March 10, 1997

**RE: BEN E. KEITH FOODS (H15-D55). GRADING PLAN FOR BUILDING PERMIT
APPROVAL. ENGINEER'S STAMP DATED FEBRUARY 28, 1997.**

**RE: BEN E. KEITH FOODS (H15-D55). GRADING PLAN FOR BUILDING PERMIT
APPROVAL. ENGINEER'S STAMP DATED FEBRUARY 20, 1997.**

**GRADING & DRAINAGE PLAN**

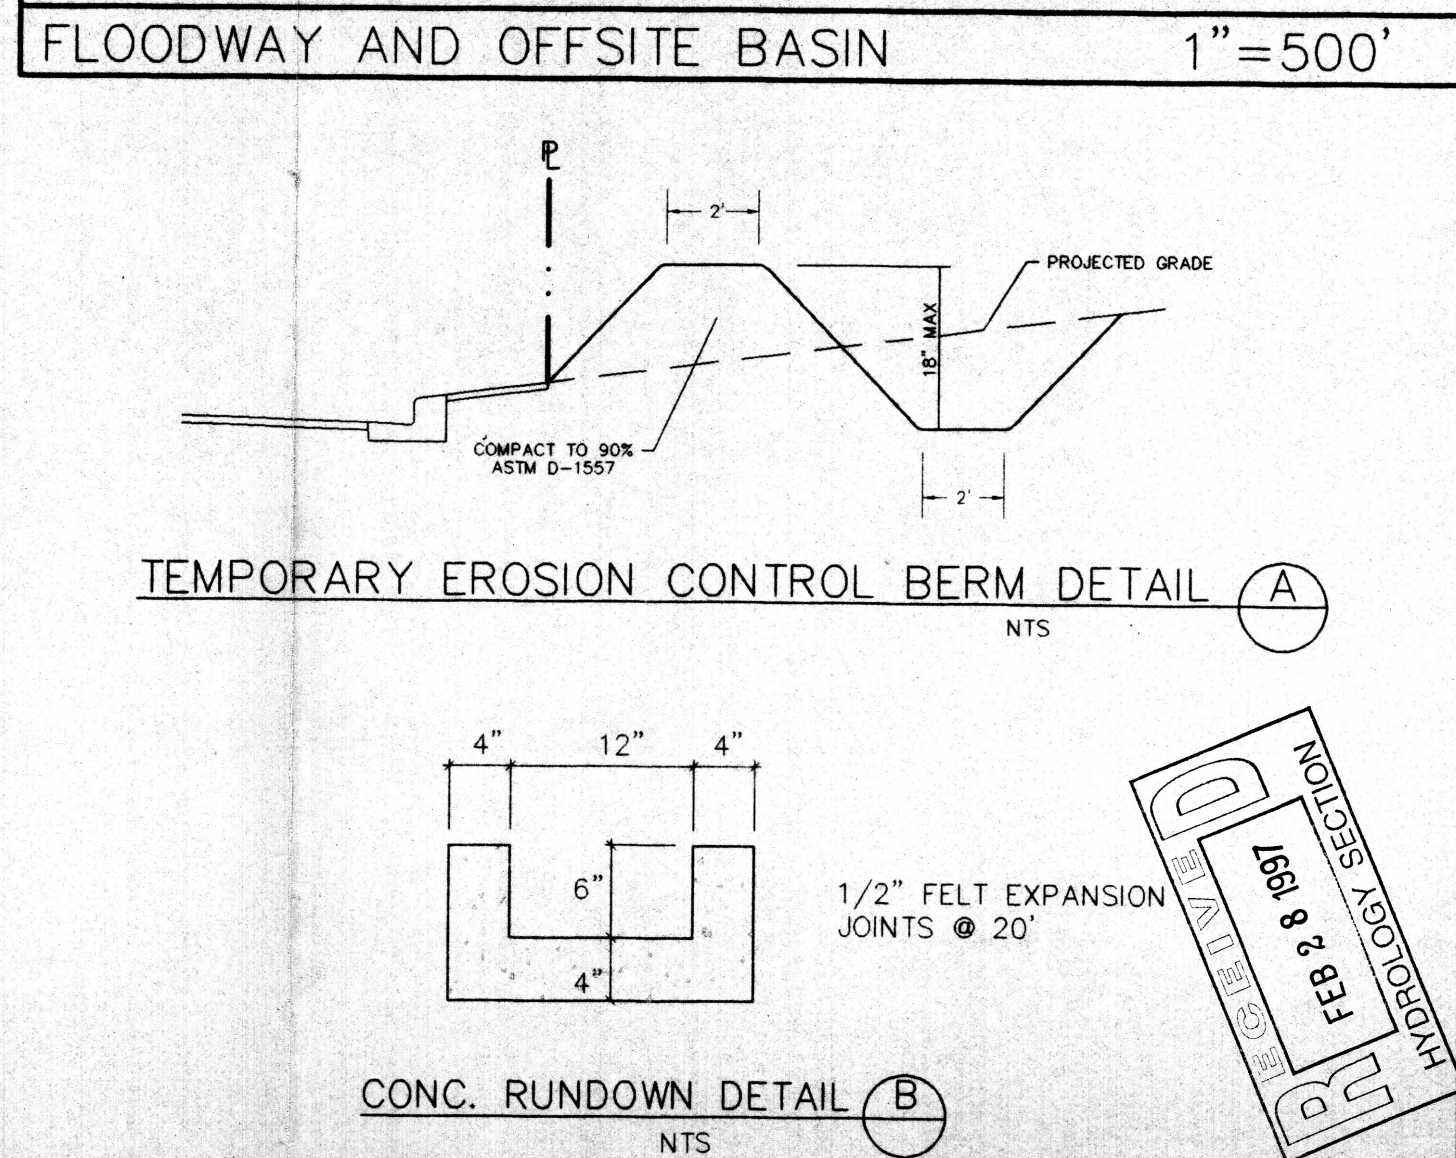
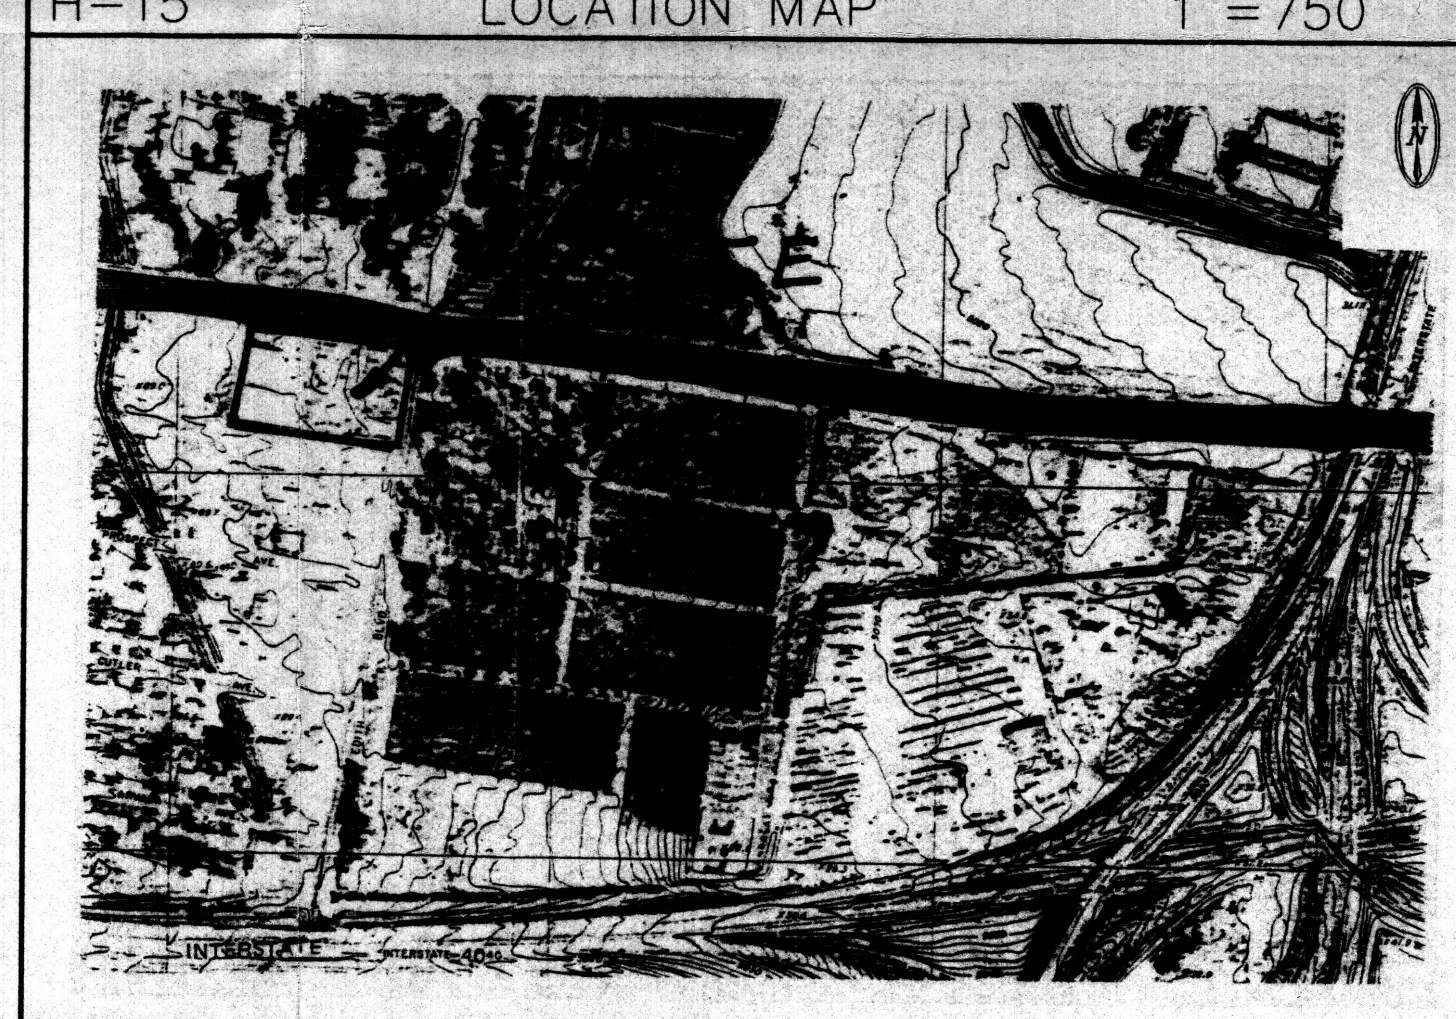
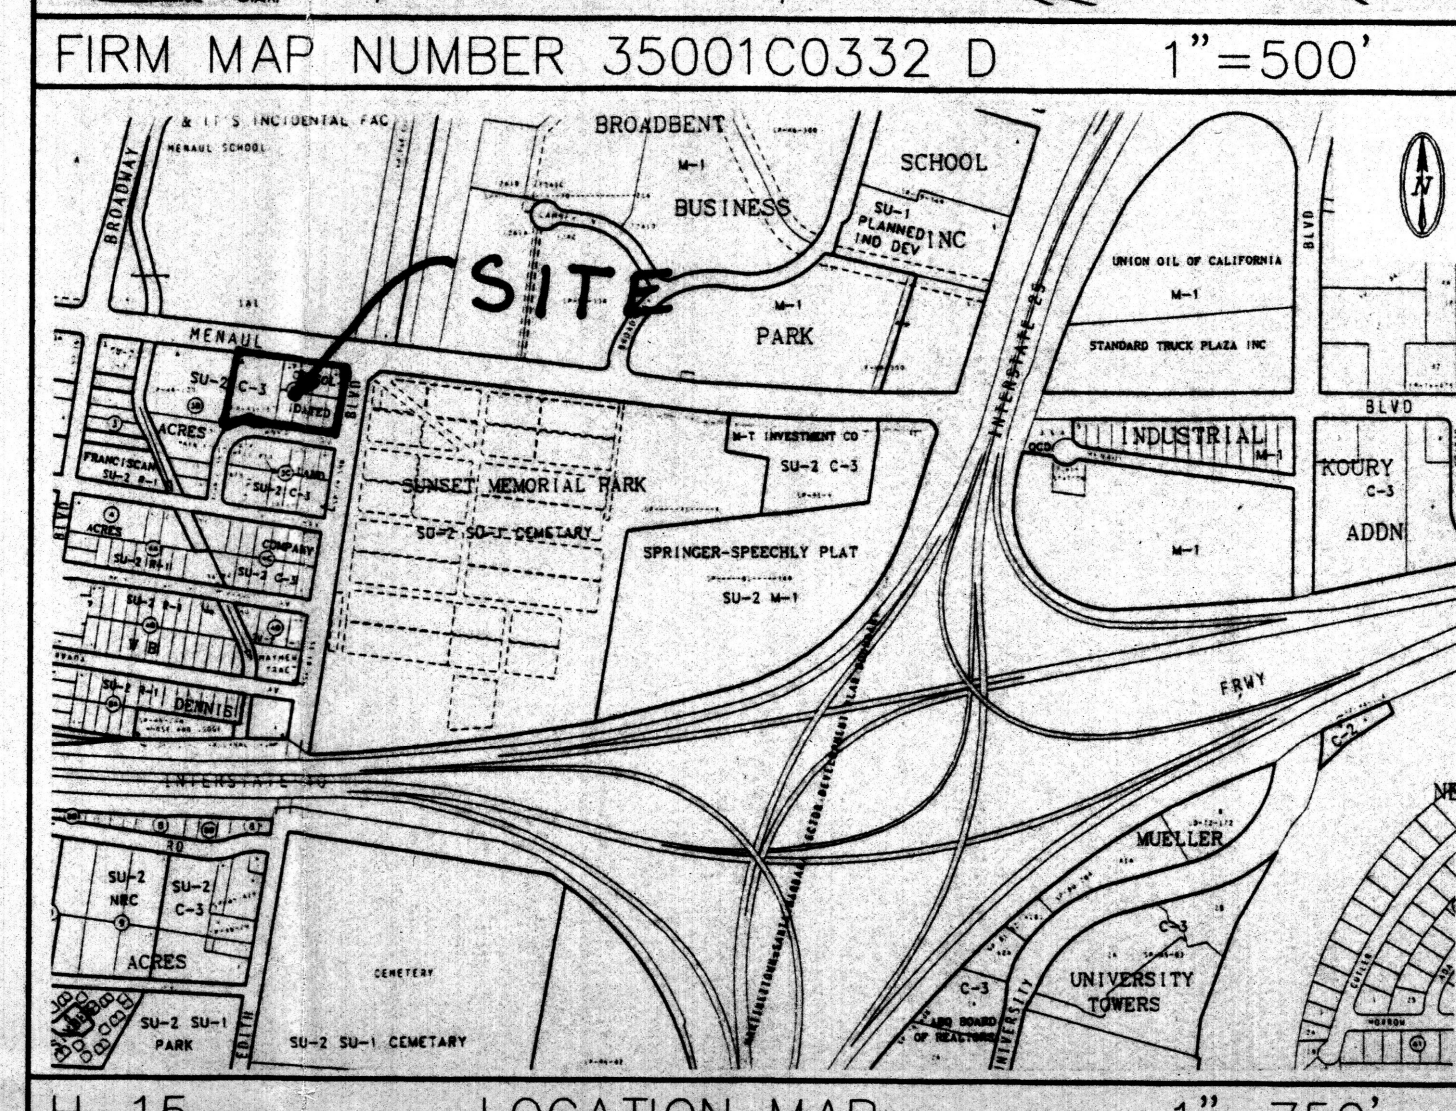
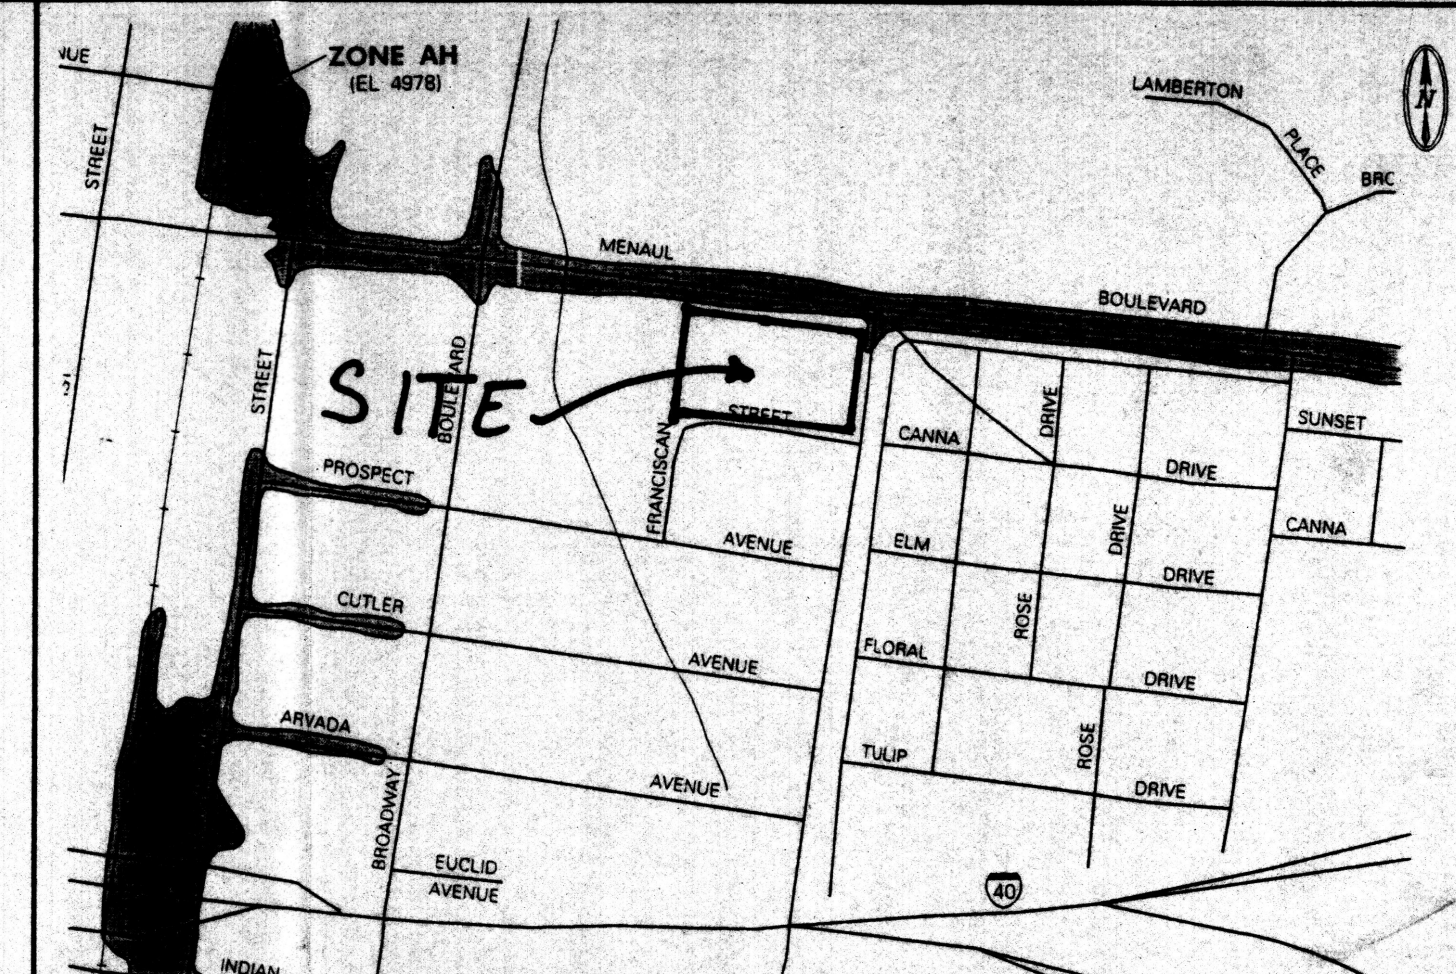
1. Please provide me a copy of the proposed plat. Remove the old lot lines from your grading and drainage plan. Also, request plat approval on the drainage information sheet.
2. Please provide the DRB number on the drainage information sheet.
3. Show how the proposed concrete rundown ties into the existing sidewalk culvert. Either use spot elevations, or show a detail.

PLAT

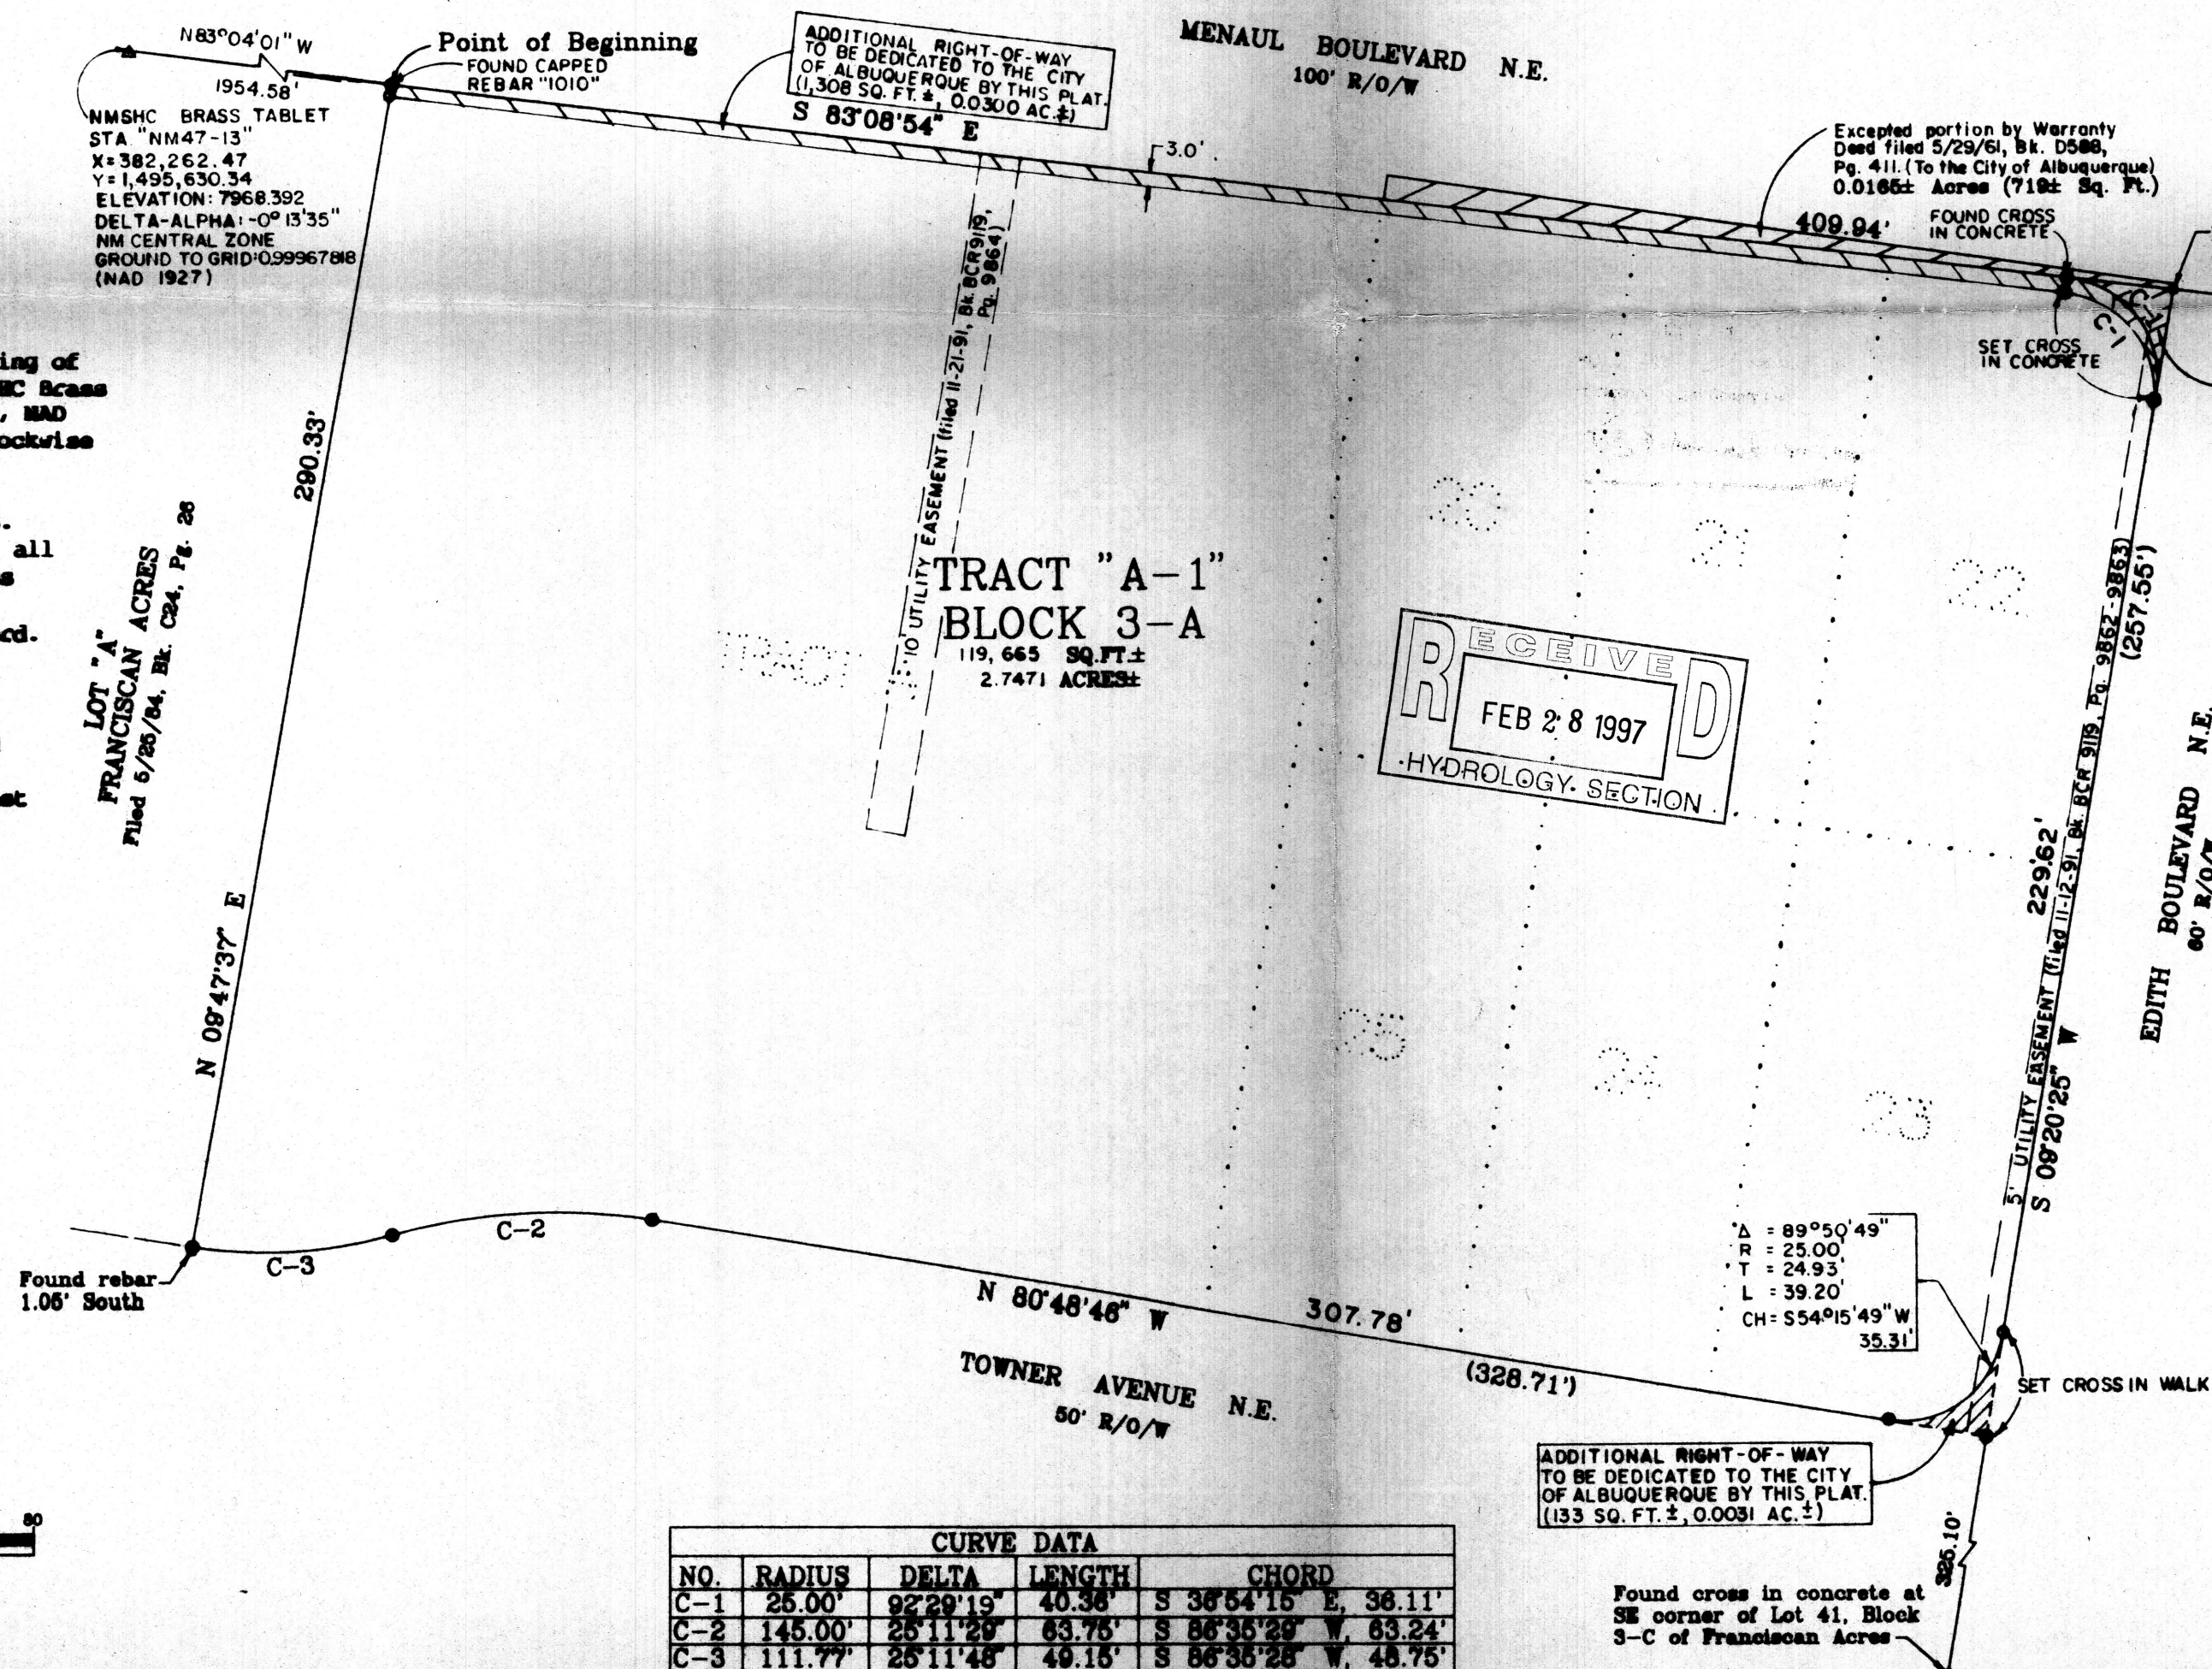
1. This project will require a re-plat. The addition cannot be located on three separate lots.
2. The platting action and "SU" zoning will require DRB approval.
3. How is storm water getting to Towner Place? Private storm water is not allowed to go over the public sidewalk. If you choose to install sidewalk culverts, a SO #19 Permit will be required.
